25th. September 2012.

Re : Planning Application - 17 Elm Grove South, Barnham, West Sussex.-EG/59/12/BR.

TITLE SITE PLAN

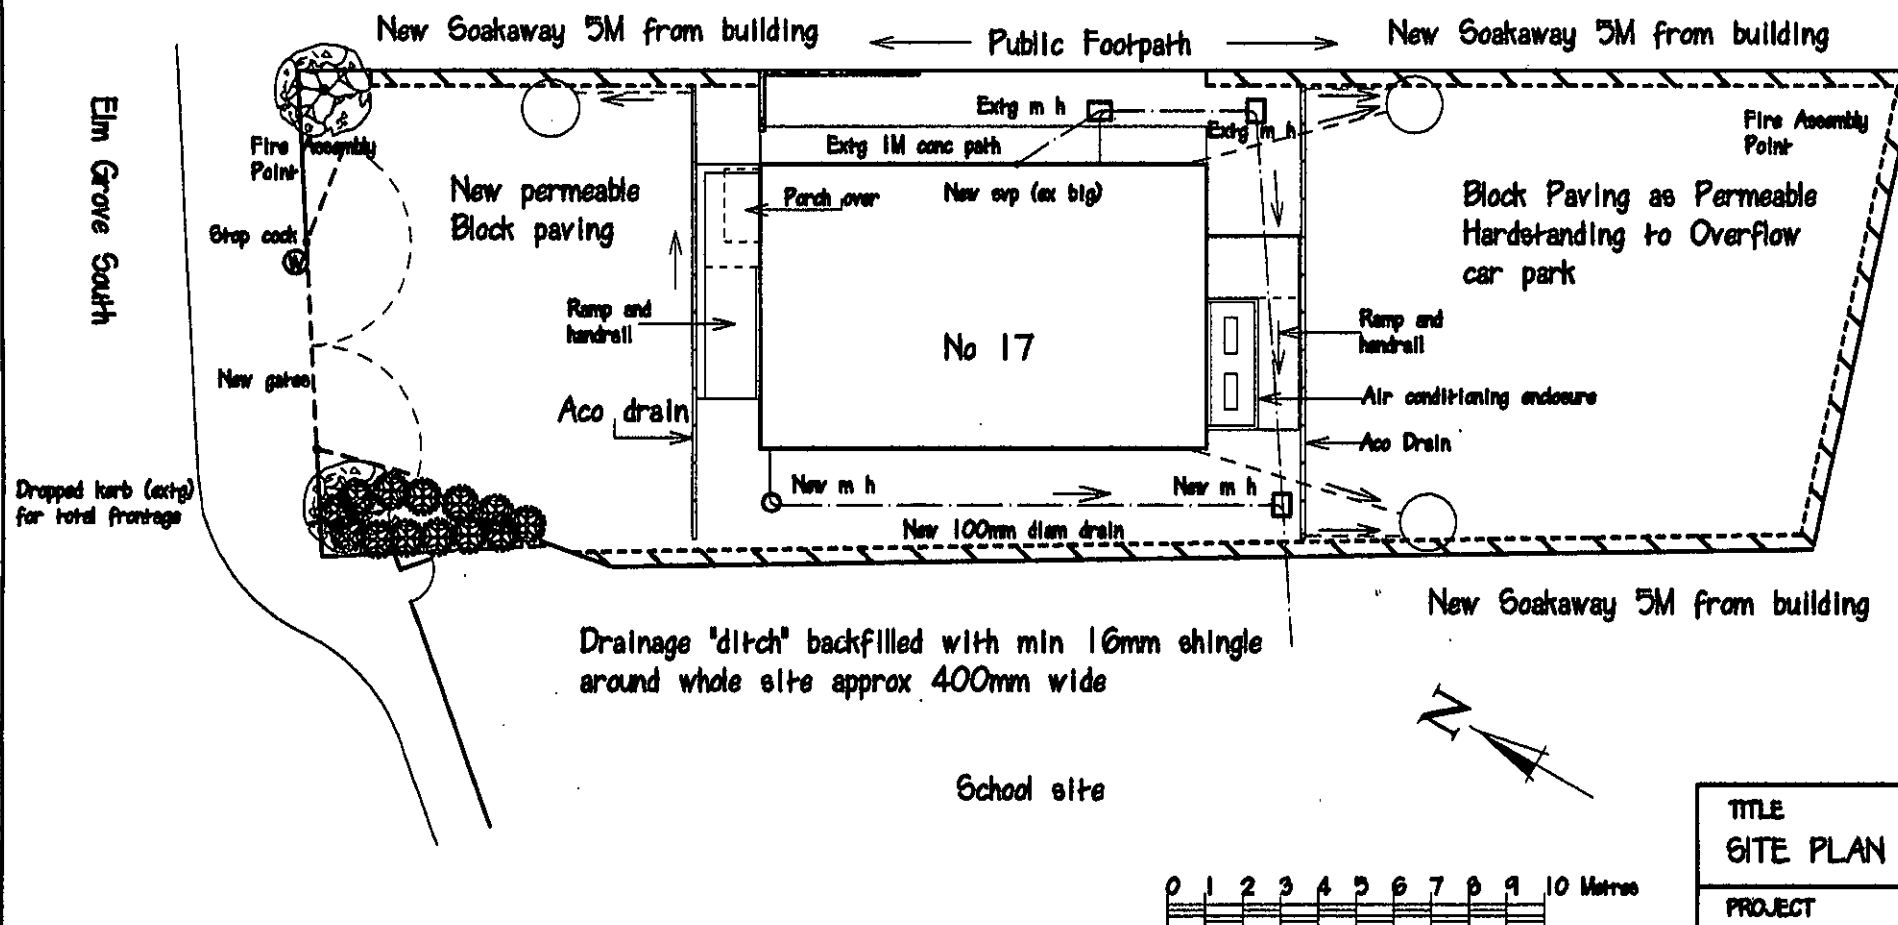
In regard to this application I do object, on grounds of inaccuracies. In Question 6, there is the claim that there is no change to any pedestrian access, nor is any new vehicle access being created, both these answers are incorrect.

Firstly this location has never had a vehicle access from the highway of Elm Grove South. The site and bungalow was formerly the school caretakers home, with a chain link fence about 1 metre high on its frontage with the footway in Elm Grove South. There was a gap in the fence, probably about a metre wide, from where a concrete footpath led to the front door of the building. There was also another pathway that led across the front of the building towards the school buildings. Some years ago there was a fire at the school and a security fence was erected around the sides of the plot adjacent to the public footpath and the footway to Elm Grove South. This fence still exists, and pedestrian access to the building was only gained from within the school grounds, until the close boarded fence was erected to separate this plot from the school grounds.

No doubt the Applicant can recall that both these paths were removed when they were clearing the gardens in the early part of 2012. They may also recall that there was no driveway, hardstanding or other indication of vehicle access on the site. There is not a 'dropped kerb' but rather the kerb along the length of footway is only slightly raised from the level of the roadway.

Secondly the pedestrian access must be altered if the proposed access from the roadway is to be double gates onto an area of blockpaving. Previously it was completely closed off with the security fence and prior to that only a normal small entrance as mentioned above.

Because of the above inaccuracies, I would hope this application is referred to the WSCC Highway Authority to ensure a licence to cross over the footpath is obtained. Also so that they can consider the safety aspects of this proposed new vehicle access to the site, for the 8-20 vehicles mentioned in the application.

In addition to the safety aspects, I hope the Planning Dept. and committee of Arun DC will be completely satisfied that the application, which although described as a 'permeable hardstanding' will not increase the likelihood of surface flooding in this area. What is being proposed is the covering over of the entire front and back gardens and side way to a former single storey dwelling.

With all the adverse publicity concerning owners of older terraced houses who have no garages or off street parking, converting their front gardens to a parking area, I cannot see that covering over an entire former garden, is anything but detrimental in a predominately residential area. We get surface flooding in heavy rain in this area and one clue may be that the adjacent estate is on an area shown as a 'brickfield' on old plans.

TITLE
SITE PLAN
(EXTERNAL LIGHTING)

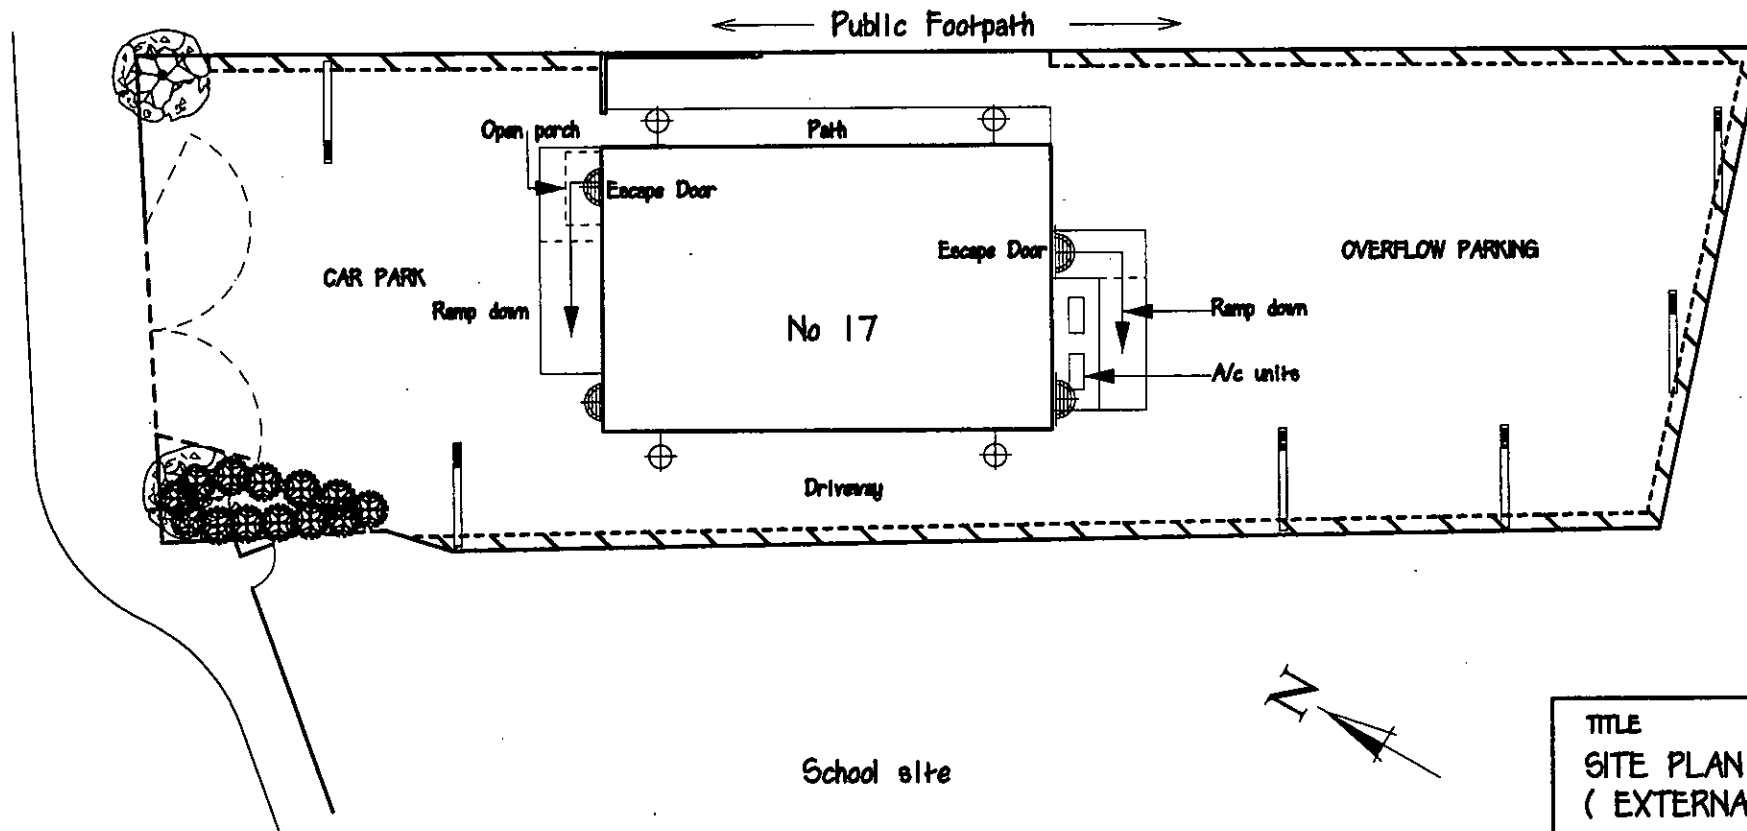
Whether the exterior lighting proposed becomes a nuisance to me as I live opposite, only time will tell, but I consider that any consideration for neighbours and local residents have not been a factor to date.
